**Consultation Response from KC,
Lead Local Flood Authority**

2025/91781 Bradley Villa Farm, Bradley Road, Bradley, Huddersfield, HD2 2JY

Discharge of details reserved by conditions 9 (cycle parking:), 10 (evc), 11, (waste), 12 (drainage), 13 (drainage), 14 (surface water), 15 (Phase II report), 19 (external materials), 20 (boundary treatments), 21 (external lighting), 23 (BNG), 24 (BGP) on previous permission 2023/92887 for change of use of egg production unit to research and development or industrial uses falling within E(g)(ii) and (iii) Use Class, and associated elevational alterations and provision of access, gates, forecourt, parking areas and landscaping

Date Responded: 29th July 2025

TITLE **DRAINAGE STRATEGY**  
**PROPOSED – NETWORK B**  
**SHEET 1 OF 1**

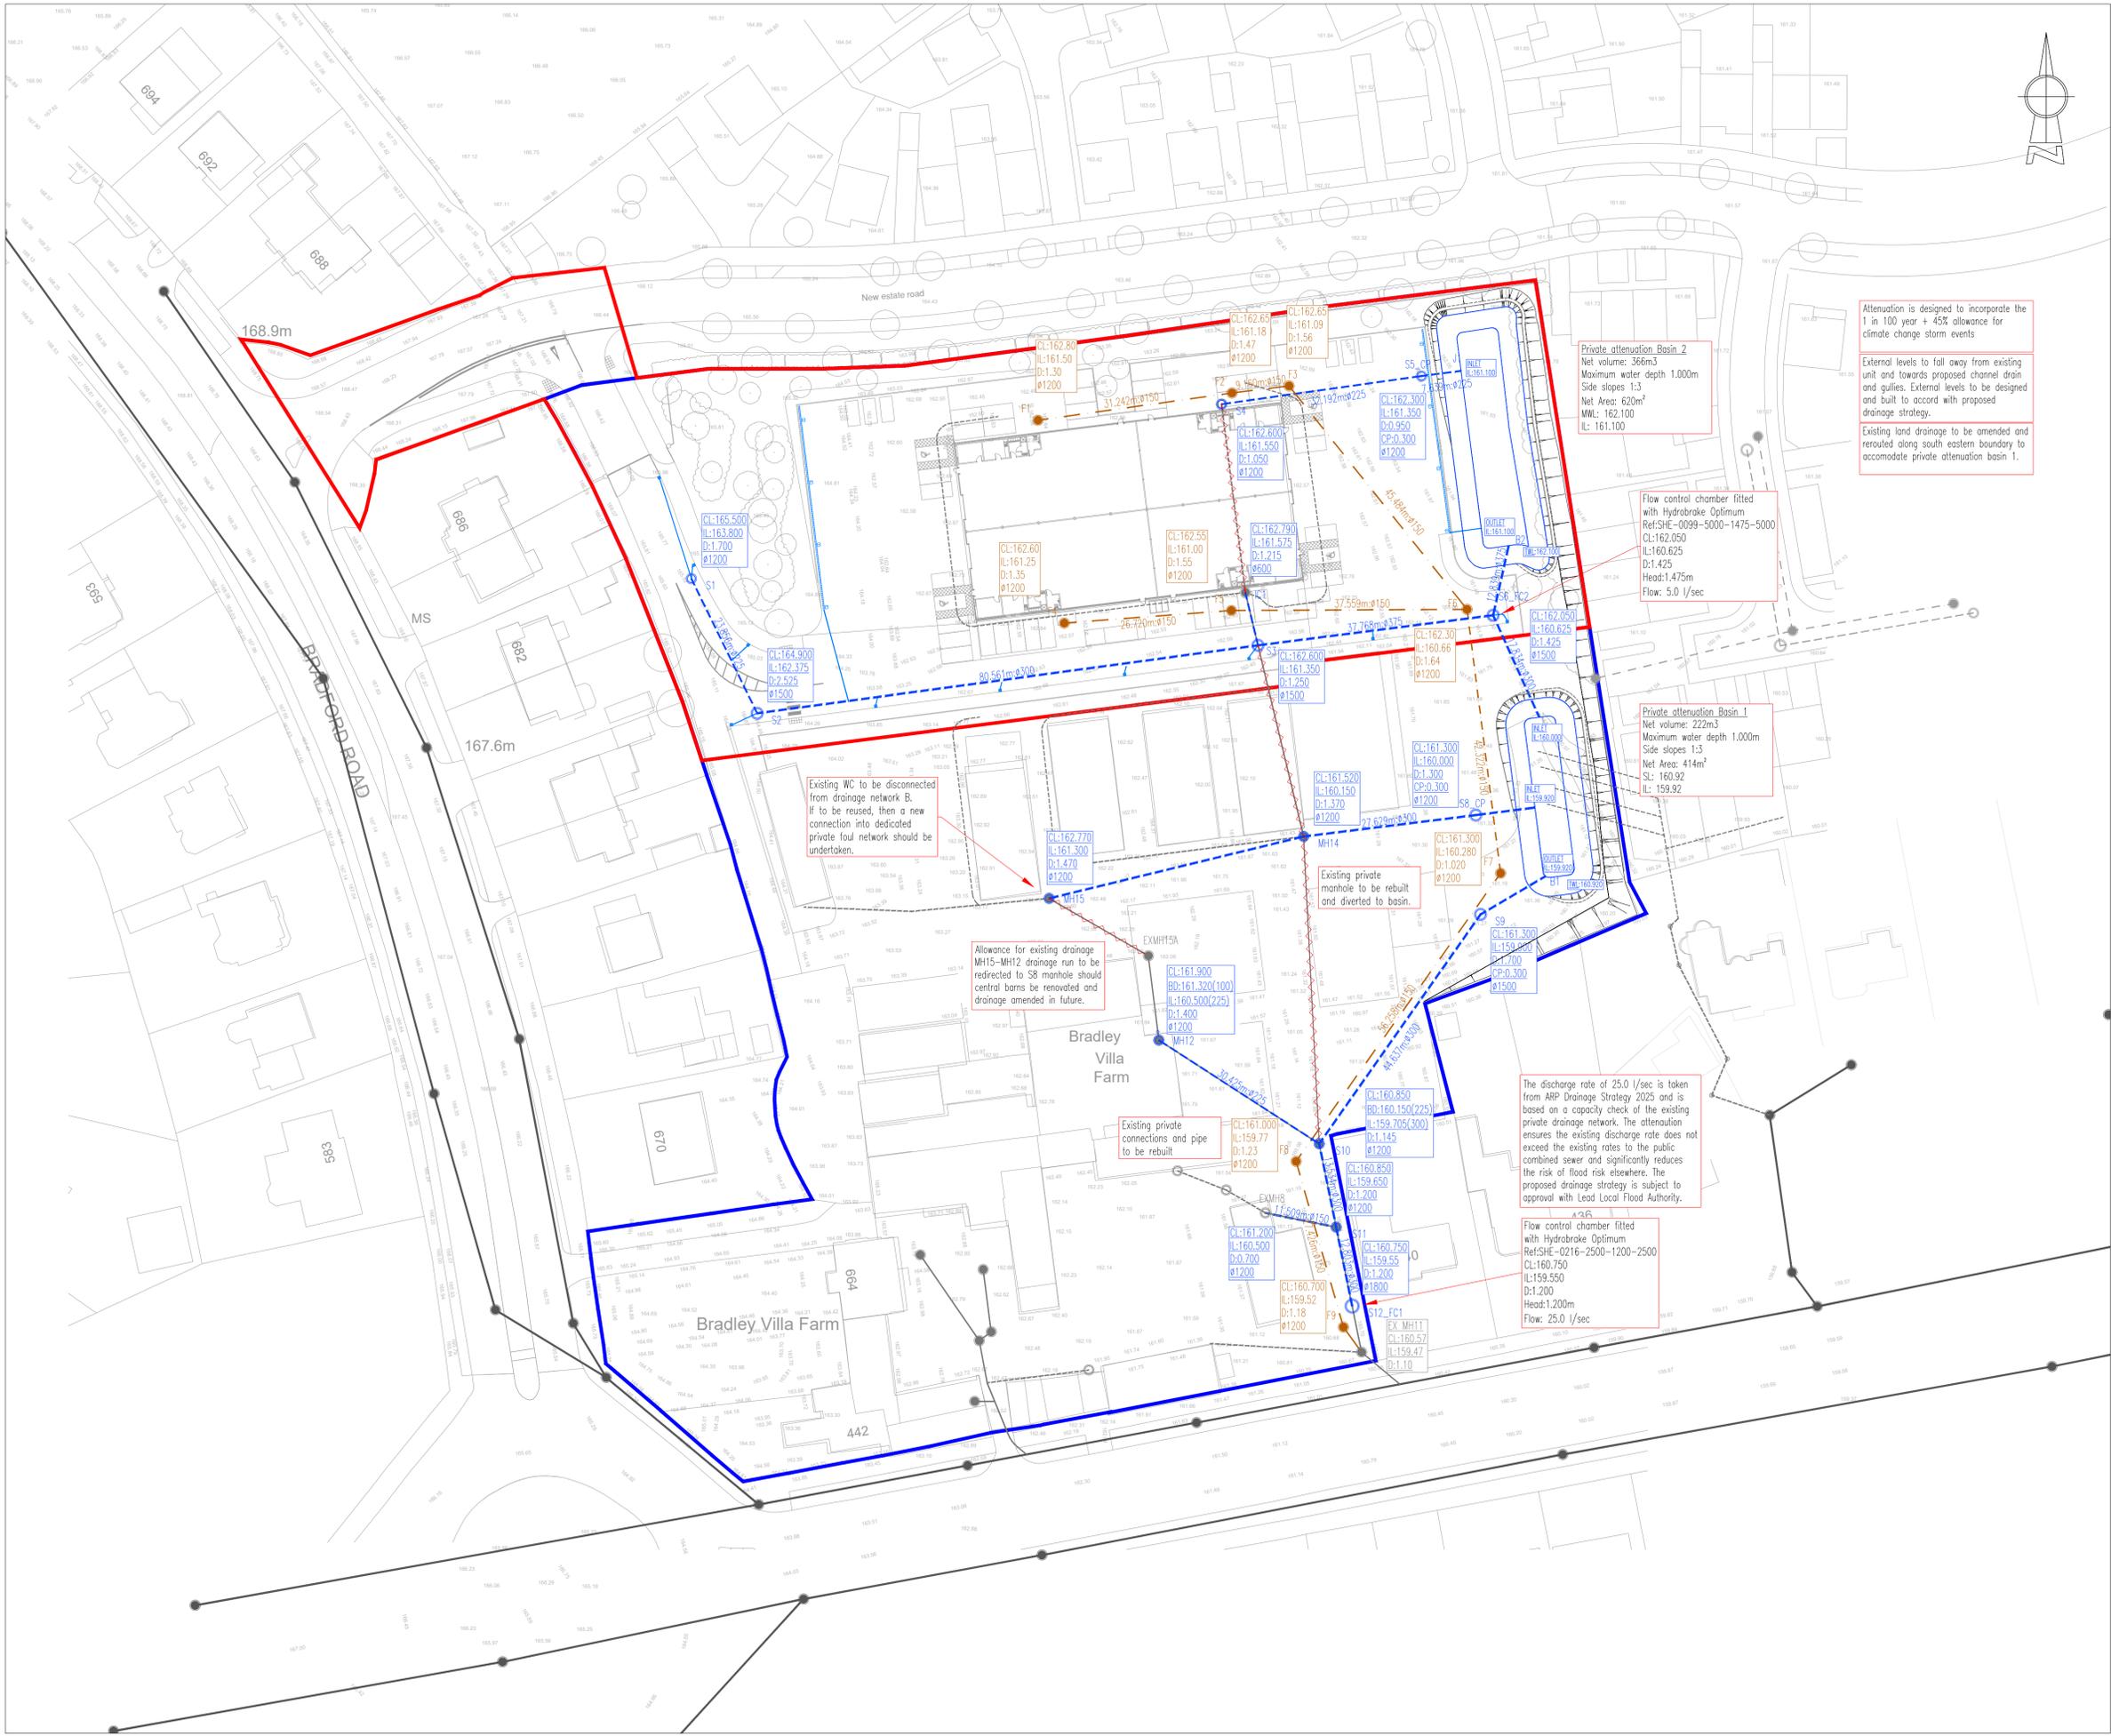
Given that a 150mm pipe at a gradient of 1 in 44 has a predicted capacity of 26.86l/s. Kirklees Flood Management will accept on this occasion that a 25l/s restriction. Should this differ from a consultation response from Yorkshire Water we would wish to be reconsulted.

We are however concerned at the amount of flooding that this system produces in a 1 in 100 year plus climate change storm event as no evidence had been provided to demonstrate that the water can be safely held on site. We currently OBJECT to this application.

TITLE DRAINAGE STRATEGY  
PROPOSED – NETWORK B  
SHEET 1 OF 1

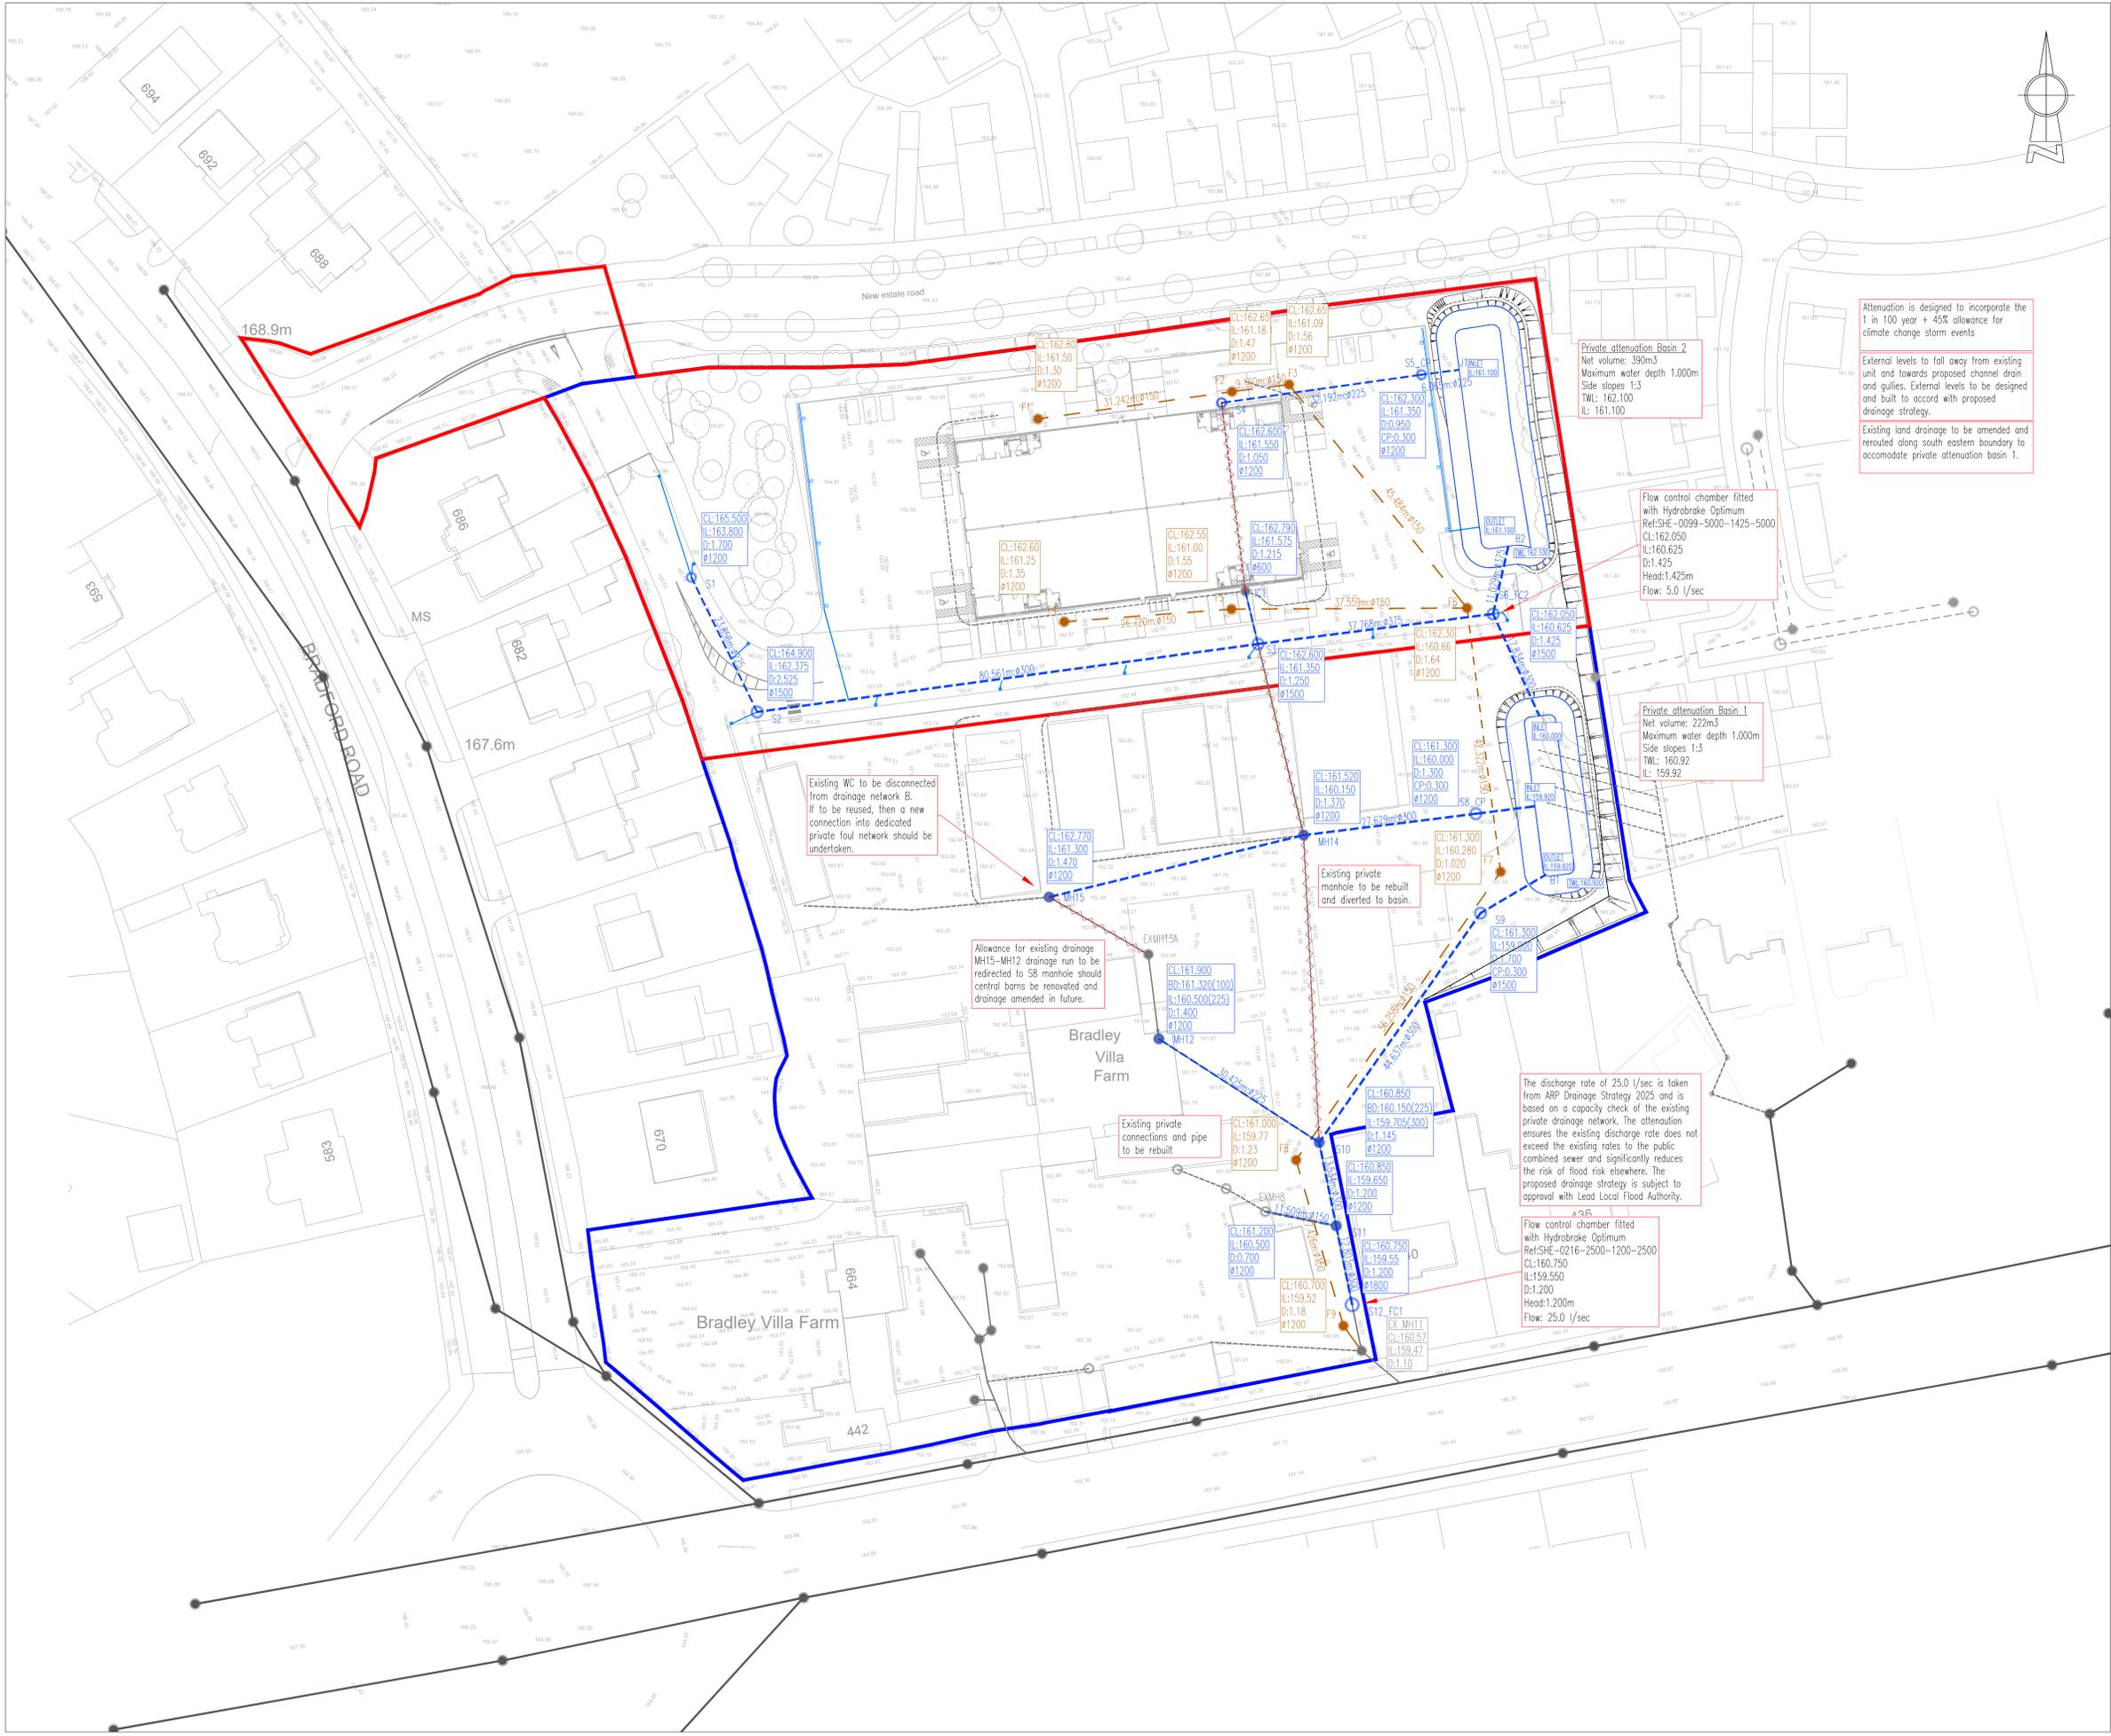
Our decision is based on the fact that an original building is being converted and not demolished, and car parking is being formalised. Otherwise, a 30% reduction on the rate produced by this methodology would apply.
